Our Ref: A/107/14/HH
Your Ref:

Application for Planning Permission for Works or Extension to a Dwelling

Development First floor side extension over existing garage

Location 5 Mill Road Angmering

5 MILL ROAD, ANGMERING
Existing details 01 A

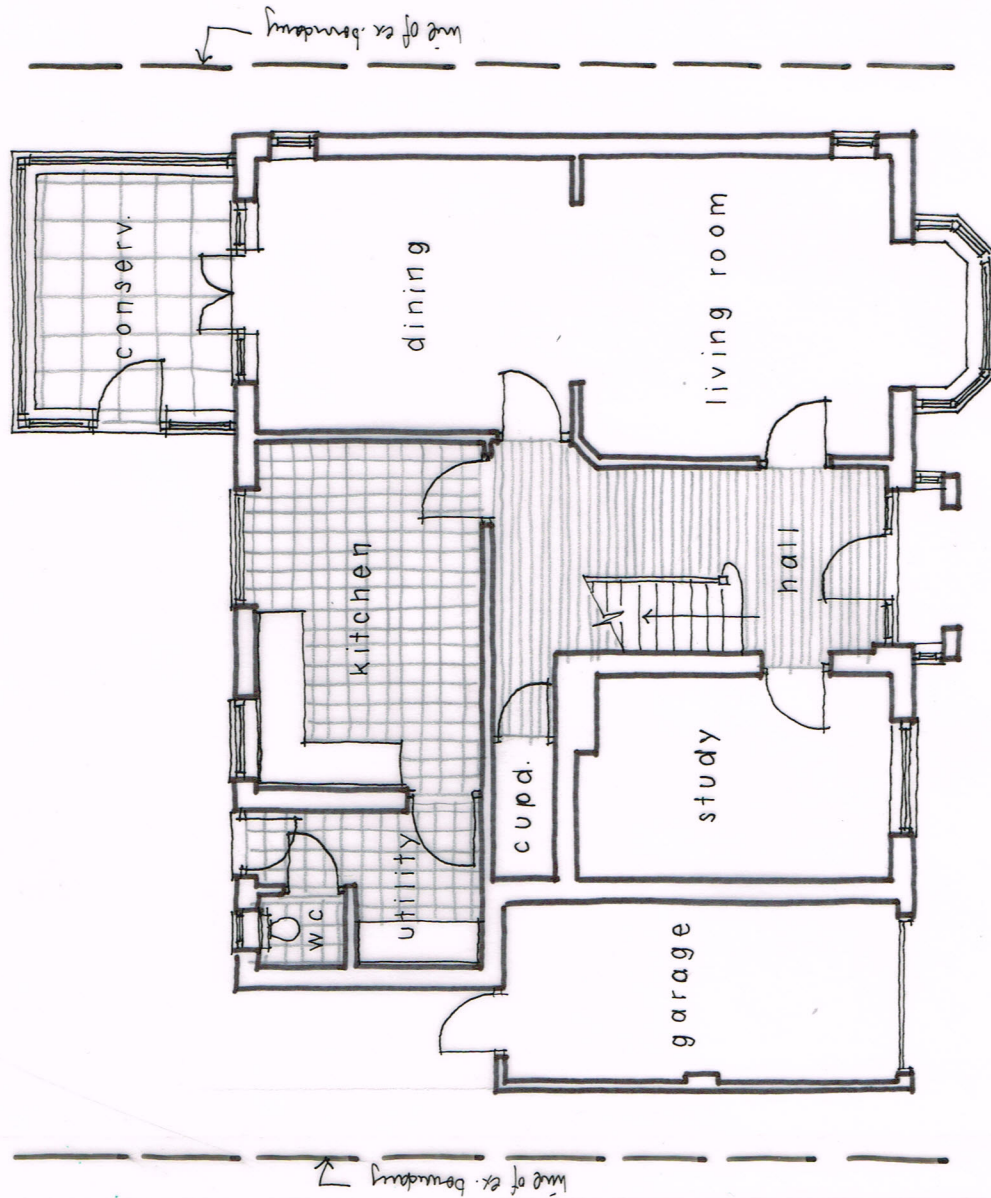
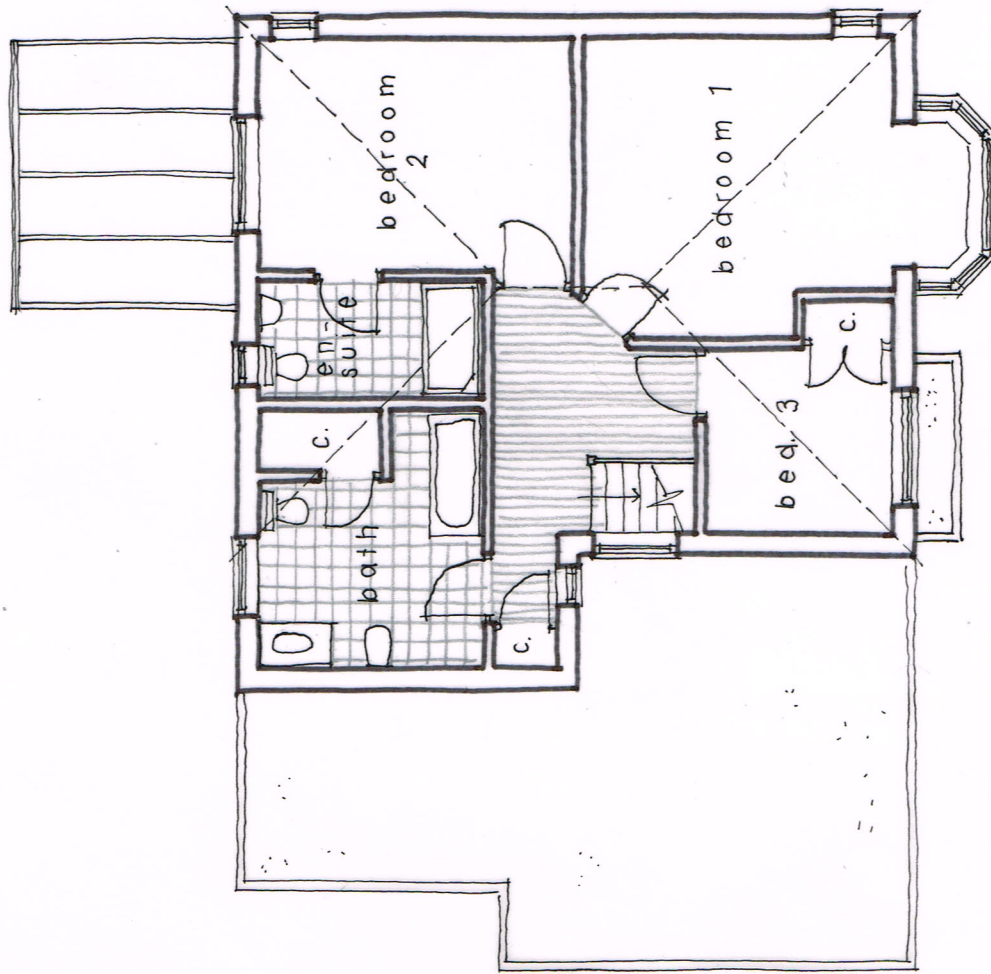
The existing side elevation at first floor level does not accord with the floor plan. Please amend accordingly.
